September 12, 2025

**Subject: Summary of Foundation Bearing Material Evaluation & 3rd Party Inspection
Lot No. 143 – (115 Green Tractor Drive)
The Farm at Neills Creek Subdivision
Lillington, North Carolina
Permit Number: 2508-0021
Project Number: 3241-14R (43207-00)
Order No.: 5255_013632**

1 MONO SLAB FOUNDATION PLAN
SCALE: 1/8"=1'-0"

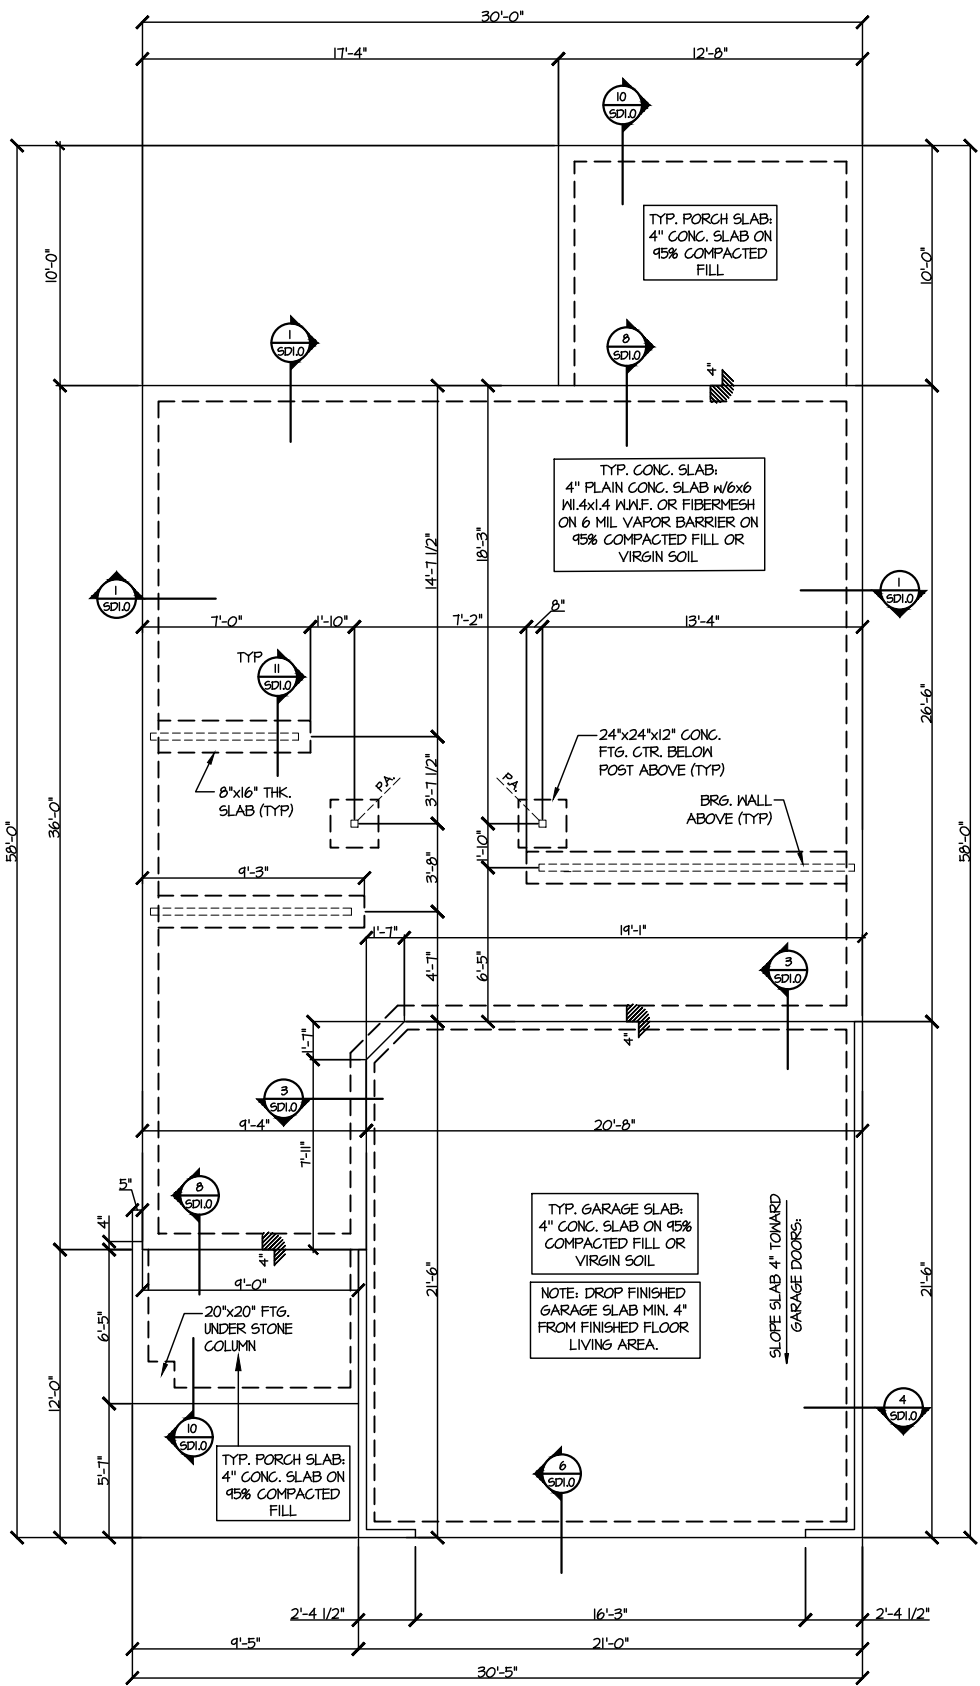
The third-party footing inspection failed during our first site visit due to the minimum footing widths and depths not being met. The contractor was informed and **UES** recommended excavating the footings in accordance with the specified plans provided onsite. We returned on September 9, 2025 and observed that the recommended remedial measures had been completed. The residential foundations were excavated approximately 18 inches wide and approximately 12 inches below the existing ground surface. We observed that the exterior and interior wall foundations, thickened slab sections, and lugs were prepared per the structural plans provided onsite. Additionally, we observed that the vapor barrier was installed in the slab area, electrical conduit was in place and had a minimum of 4 inches of clearance from the top of the concrete slab, and that the foundation insulation had been placed along the exterior wall foundations.

UES tested the four exterior wall corners of the residential foundation and fill soils were encountered to a minimum approximate depth of 3 feet below the foundation bearing elevation. **UES** assumes that the fill placement was observed and tested to verify that the fill material was placed and compacted properly. Based on the results of our DCP testing and the assumption that the fill placed throughout the building pad is similar or better than the properly compacted fill material encountered in the hand auger borings, the soils encountered are suitable for support of the residential structure utilizing a net allowable soil bearing pressure of **2,000 pounds-per-square-foot**. The foundation bearing soils are in accordance with HUD requirements.
